TOWN AND COUNTRY PLANNING ACT**HIGHWAY REPORT ON PROPOSALS FOR DEVELOPMENT**

DISTRICT:	Bassetlaw	Date received	27/02/2023
OFFICER:	Ellie Grant		
PROPOSAL:	Demolition of an Existing Derelict Bungalow and Erection of a Detached House and Garages with New Vehicular Access	D.C. No.	B/23/00199/FUL
LOCATION:	Littlewood House Wheatley Road Sturton Le Steeple Retford Nottinghamshire DN22 9HU		
APPLICANT:	Mr Byron Foster

SITE PLAN

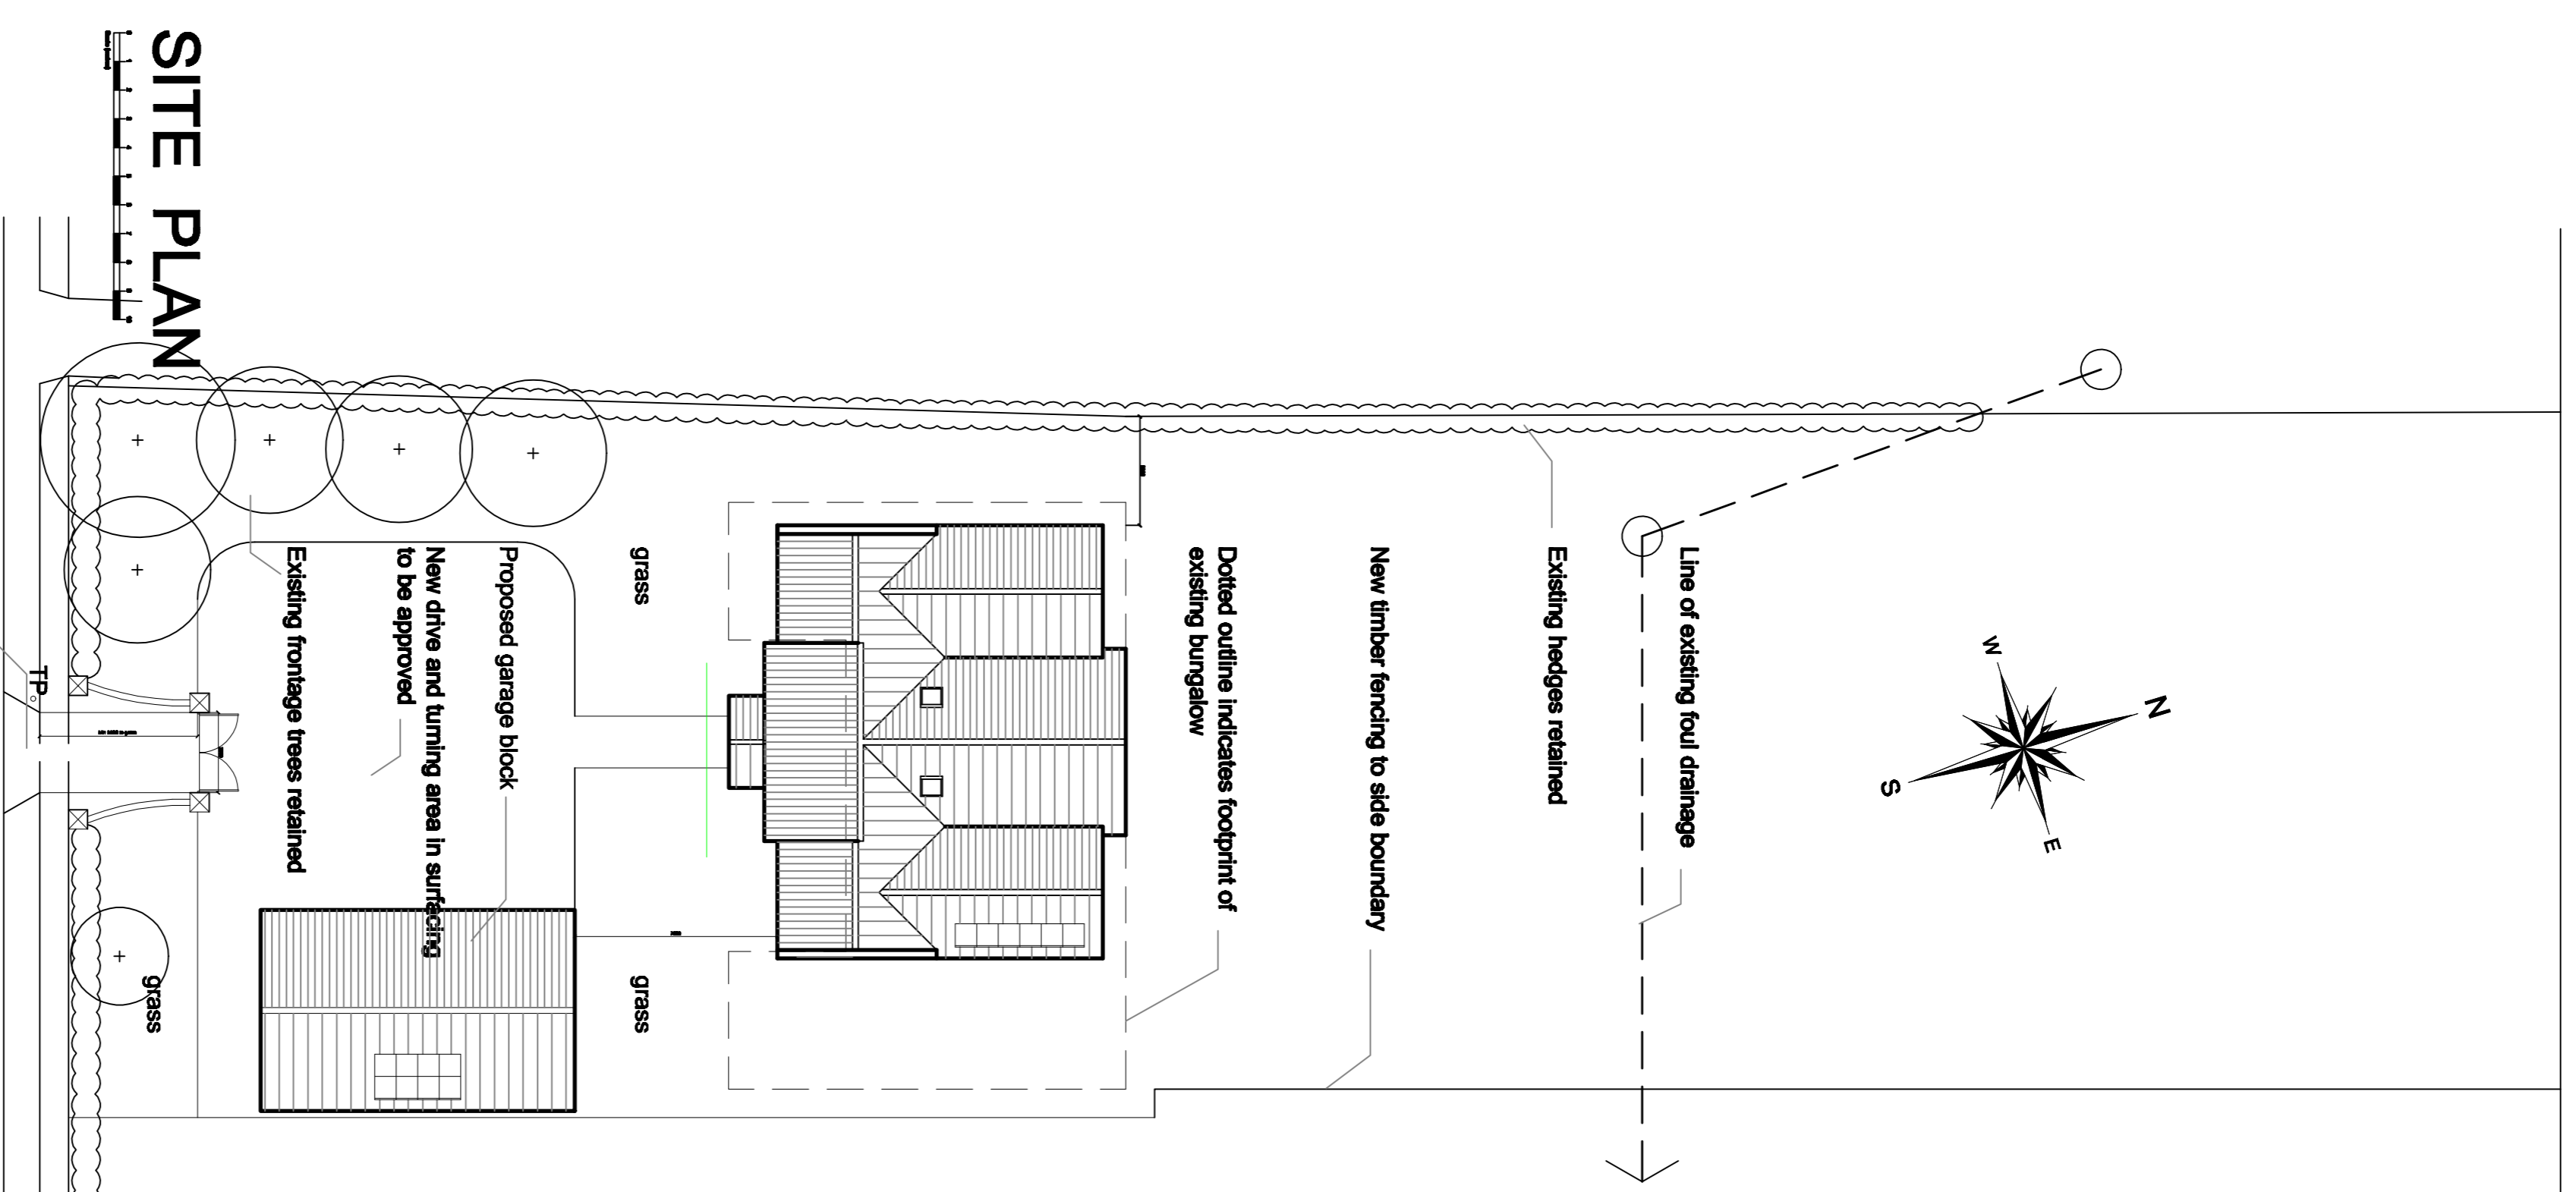
- Prior to the dwelling being occupied the driveway shall be surfaced in a bound material (not loose gravel) for a minimum distance of 6.0m from the highway boundary, shall be drained to prevent the unregulated discharge of surface water onto the public highway, and a dropped vehicular footway/verge crossing shall be provided as detailed on Drawing Number 2301.28.03 Rev A.
